Reference No: 2020/62/94340/E

Site Address: Hazeldean, 16, Liversedge Hall Lane, Liversedge,
WF15 7DB

Description: Erection of two storey and single storey rear extension

Officer Report – 2020/94340

DRG No. SD/03C SCALE 1:100 @ A2

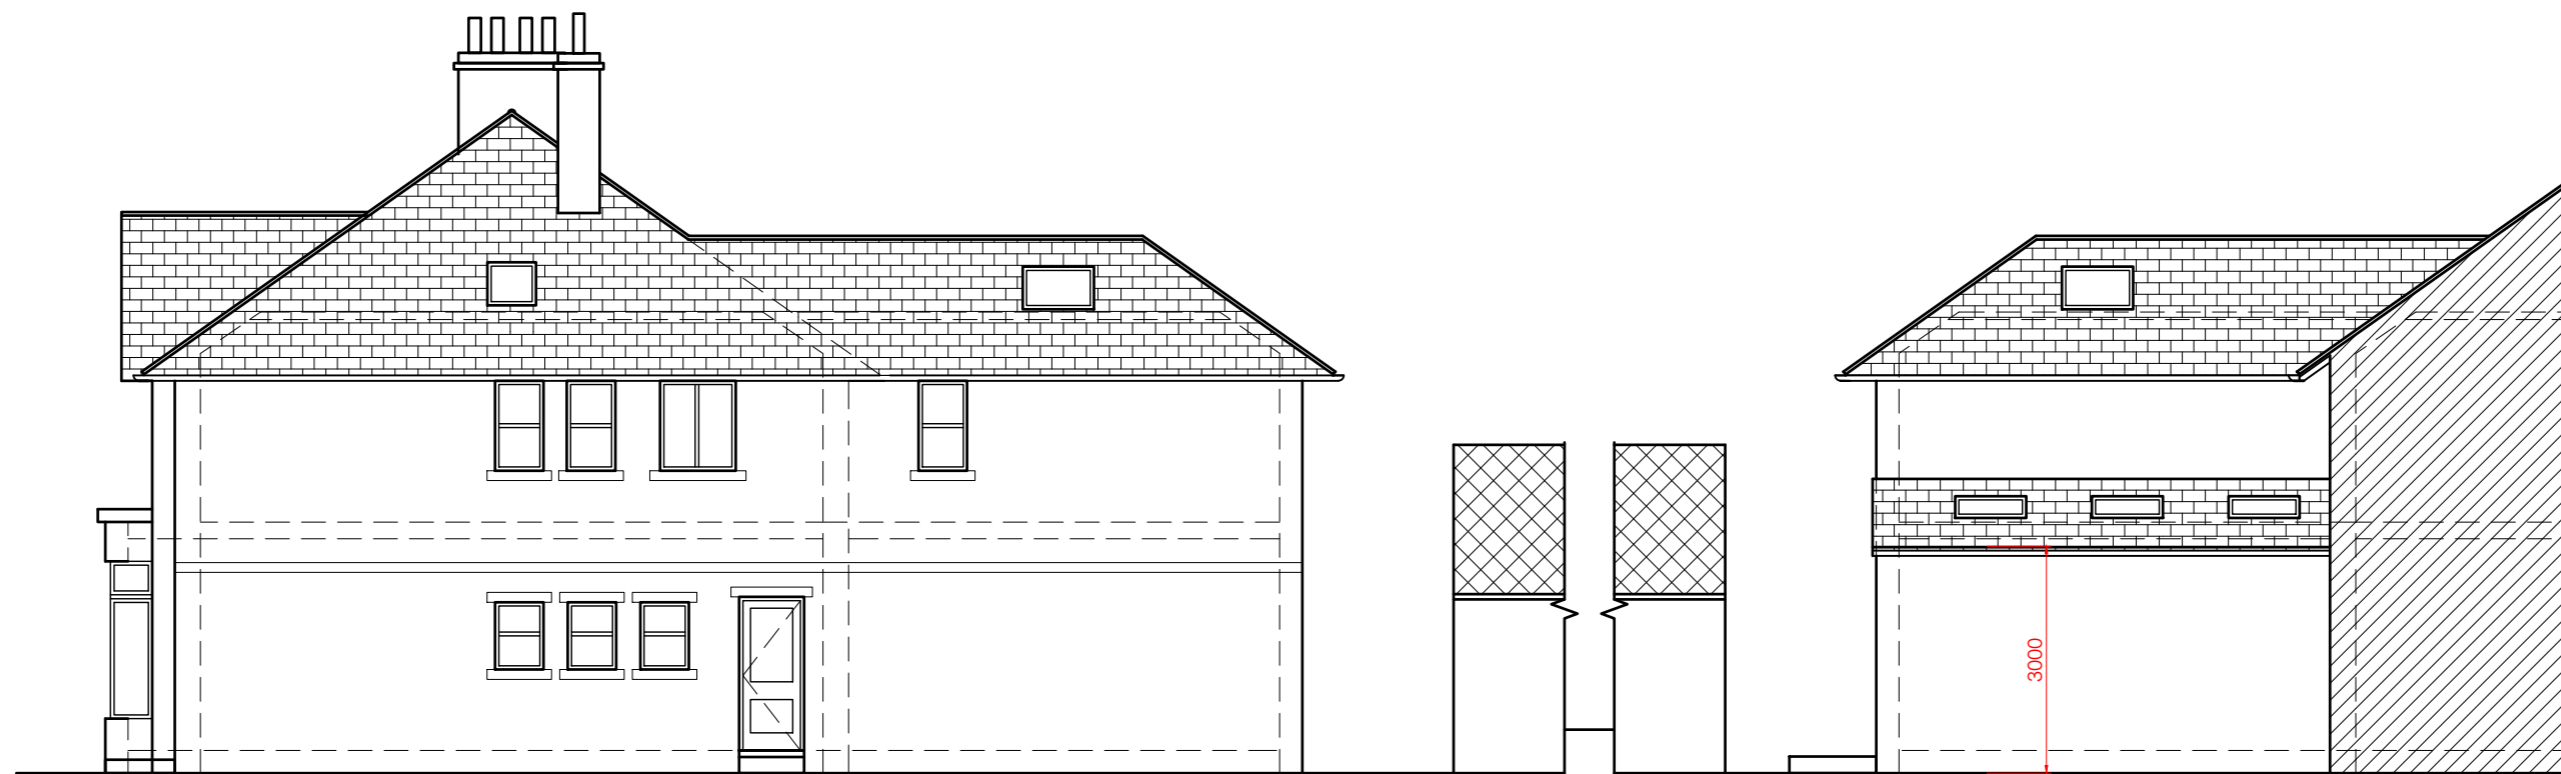
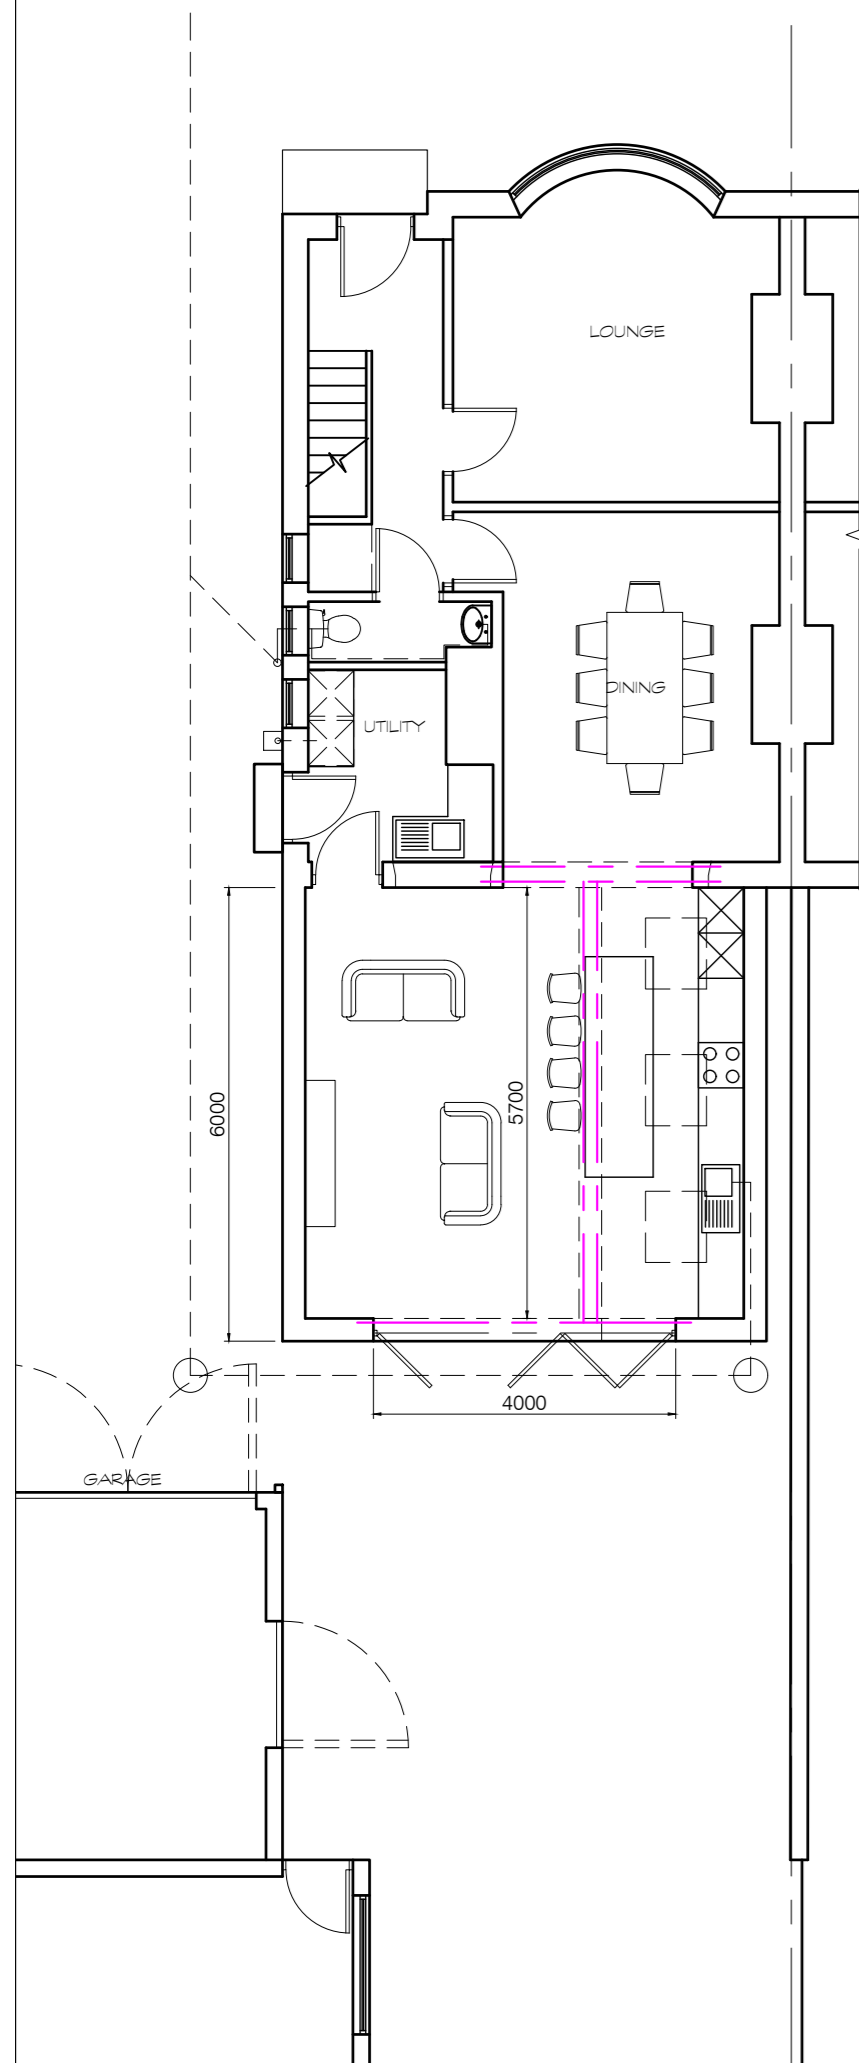
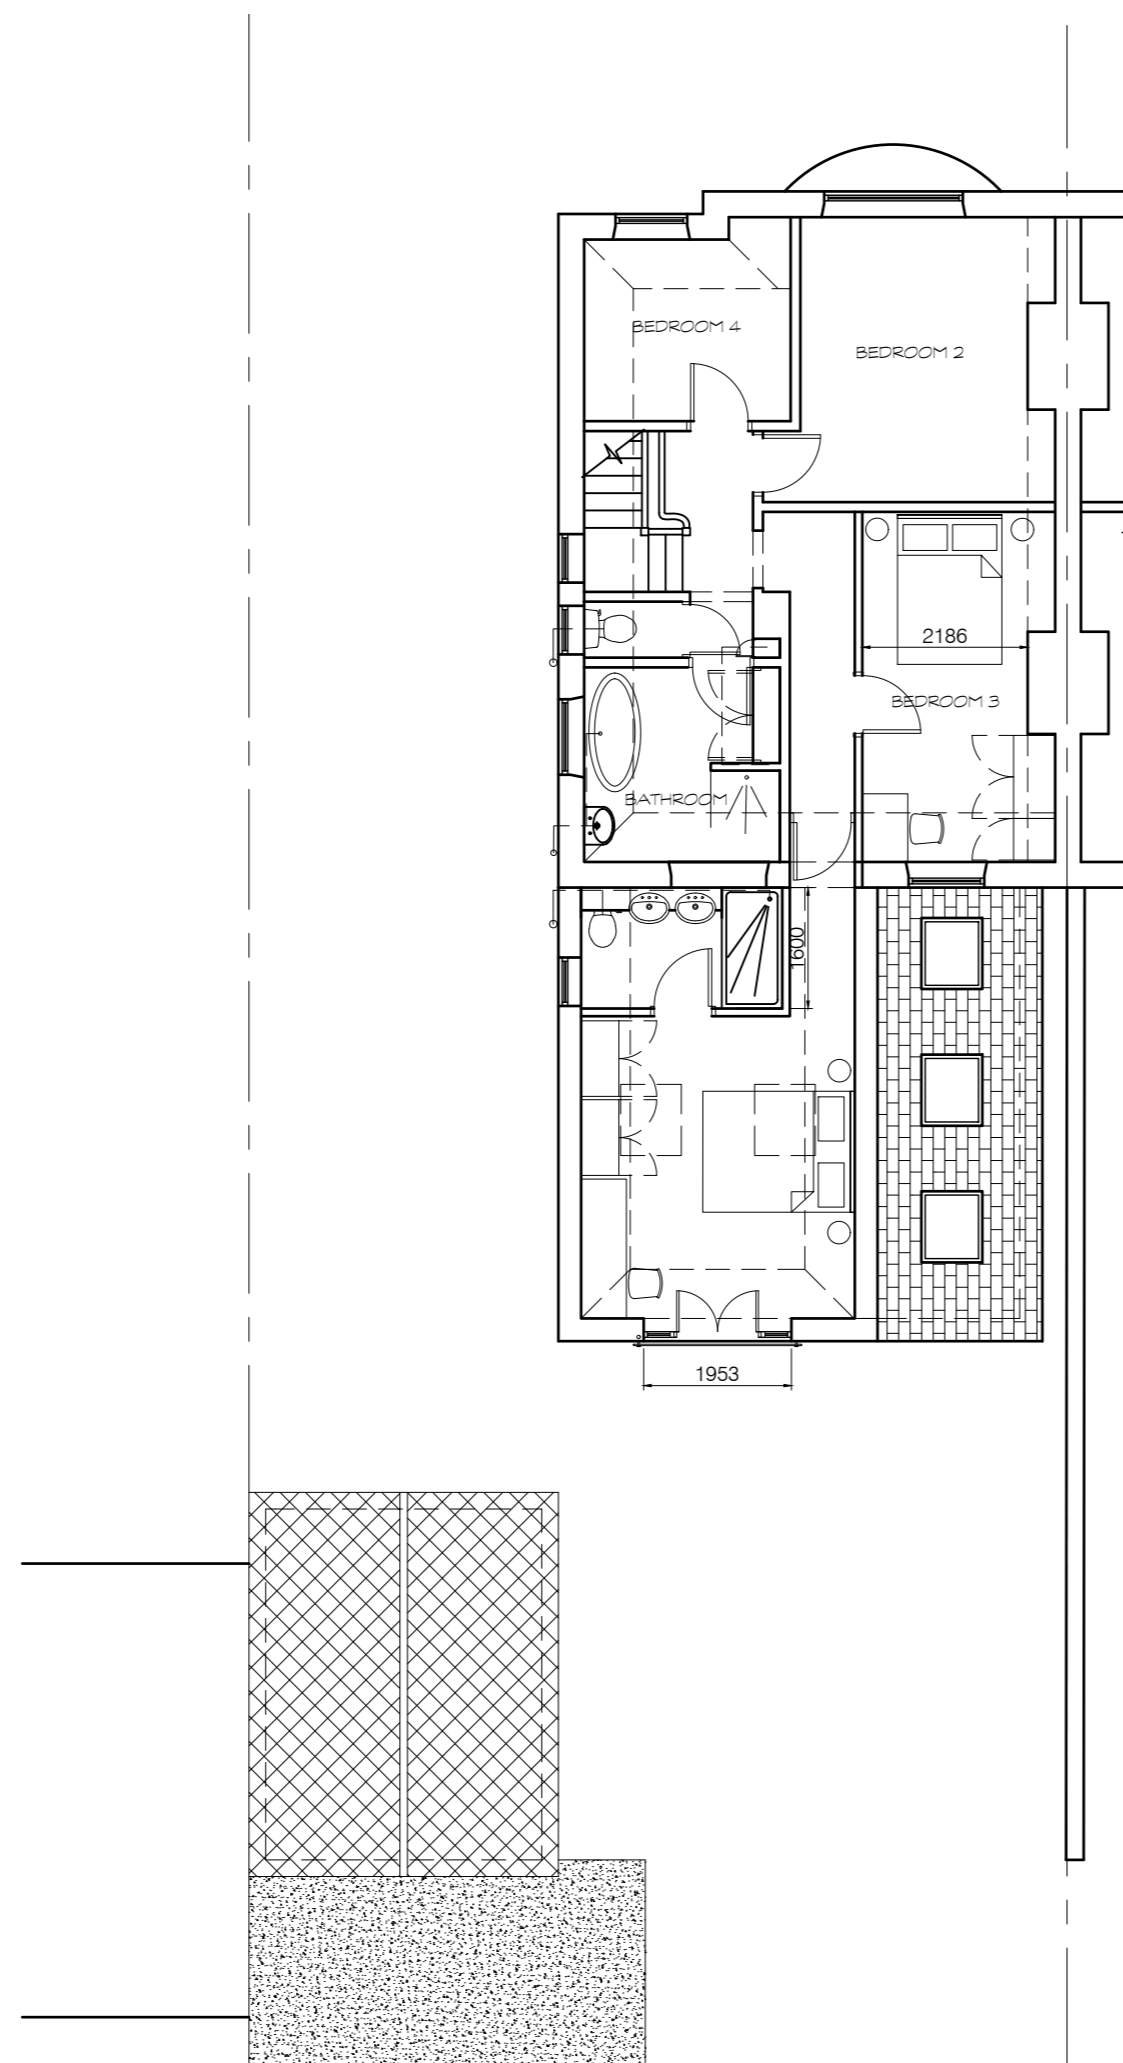
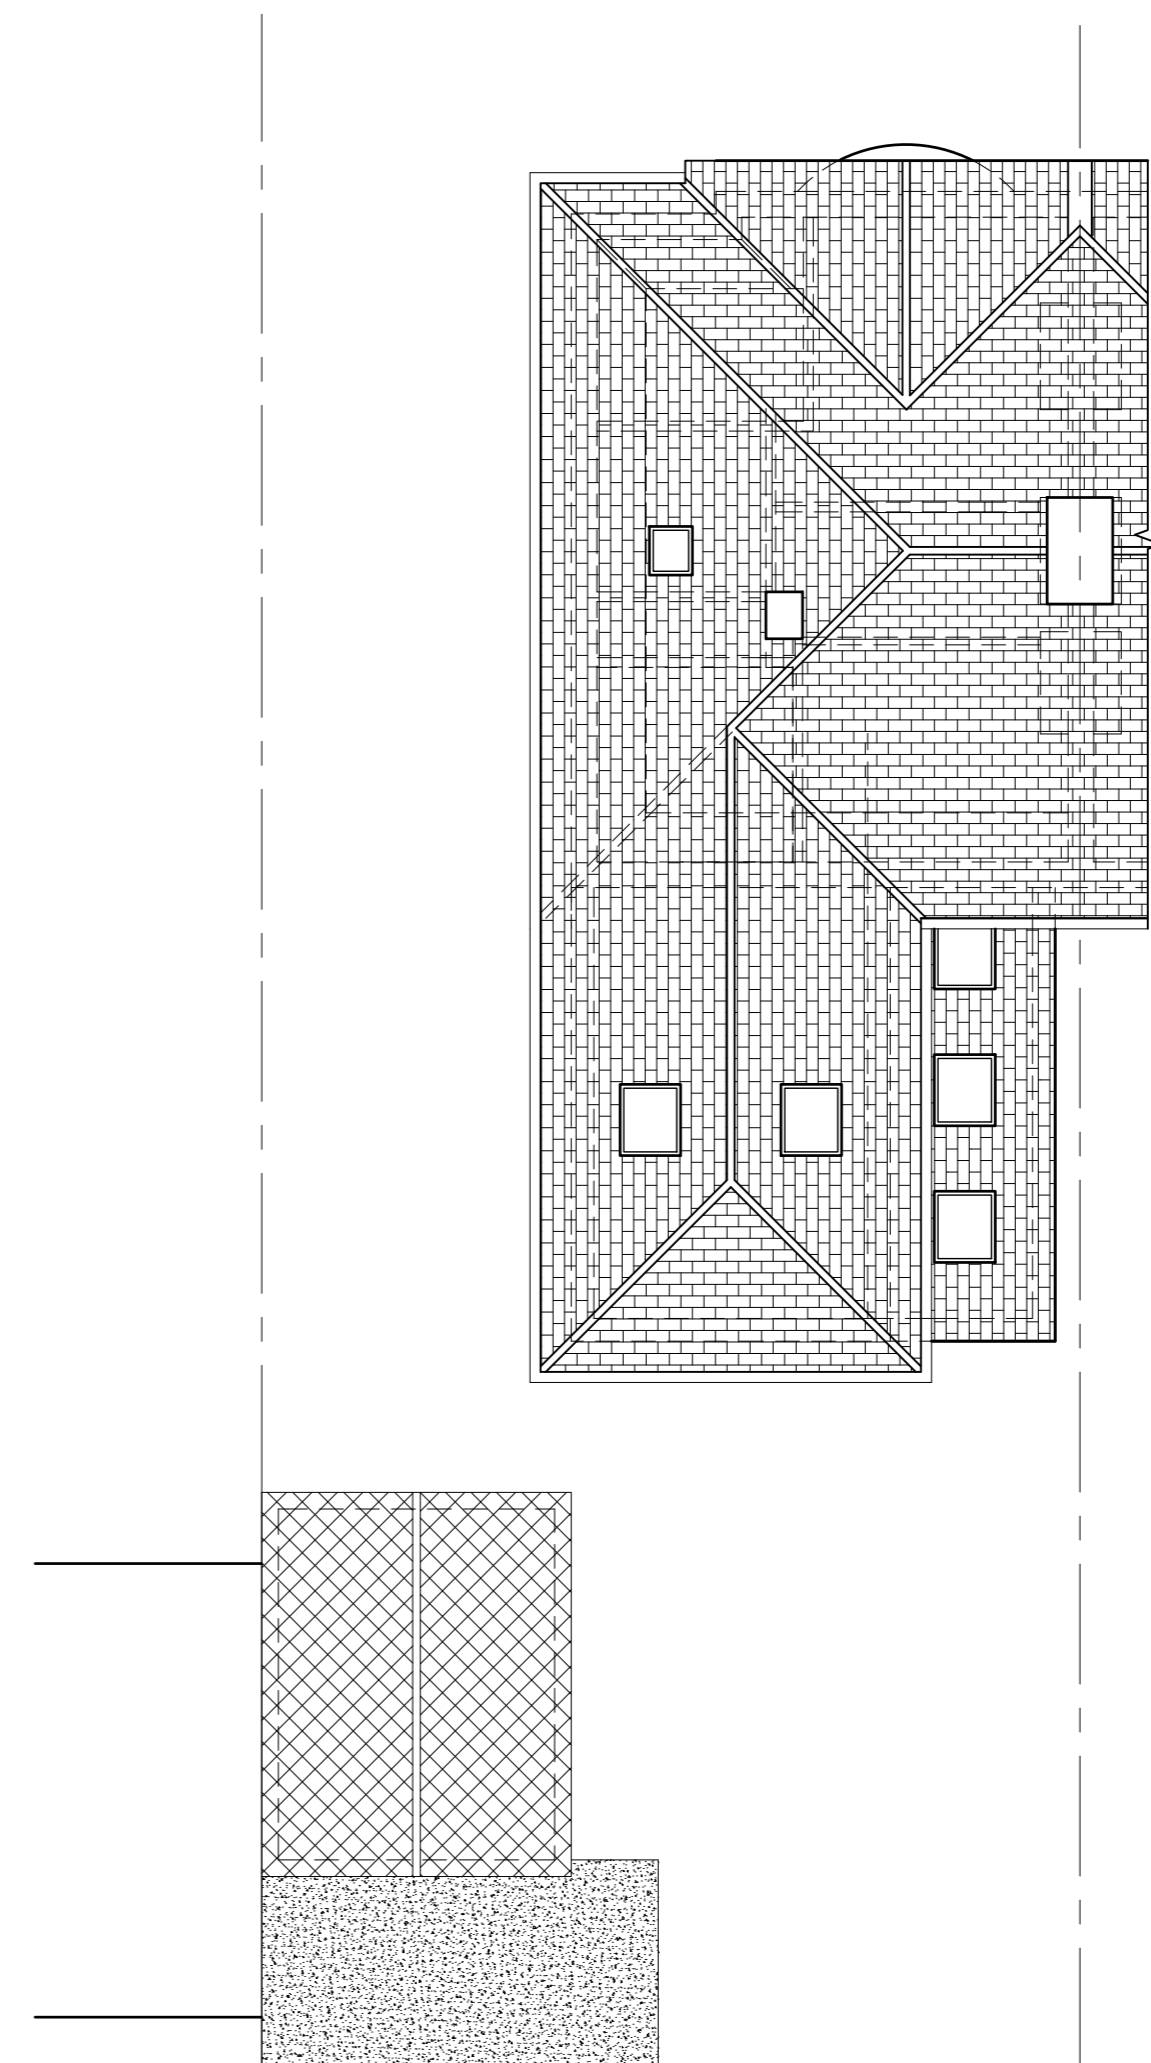
Amendments were received to replace flat roof element, with a mono-pitched roof design.

In terms of overlooking, one small window is shown in the west elevation as proposed. However, this would be for an en-suite bathroom, which could be controlled by condition and obscurely glazed.

It is noted that another new window is shown in the same side elevation at first floor level in the original part of the house. It also appears to be outside the stipulations of permitted development rights, but not included in the description of the proposed development and so is outside the scope of this application.

The proposed extensions have some potential for an overshadowing and overbearing impact. However, the double storey element has been stepped in from the mutual boundary around 2.5m and the overall height is well below that of the original part of the house. The eaves height of the single storey element is also restricted in height and the roof plane slopes away from the boundary.

No openings are shown in the facing side elevation (except velux windows) and it is recommended that new opening be controlled by condition.

4. Notwithstanding the provisions of the Town and Country Planning (General Permitted Development) (Amendment) (No.2) (England) Order 2015 as amended (or any Order revoking or re-enacting that Order) no doors, windows or any other openings (apart from any expressly allowed by this permission) shall be created in the side elevations of the rear extensions hereby approved.

5. The windows to an en-suite at first floor level in the west facing side elevation of the extension hereby approved shall be obscurely glazed (minimum privacy level 4). Notwithstanding the provisions of the Town and Country Planning (General Permitted Development) (Amendment) (No.2) (England) Order 2015 as amended (or any Order revoking or re-enacting that Order) the windows shall be so retained thereafter or replaced on a like for like basis.
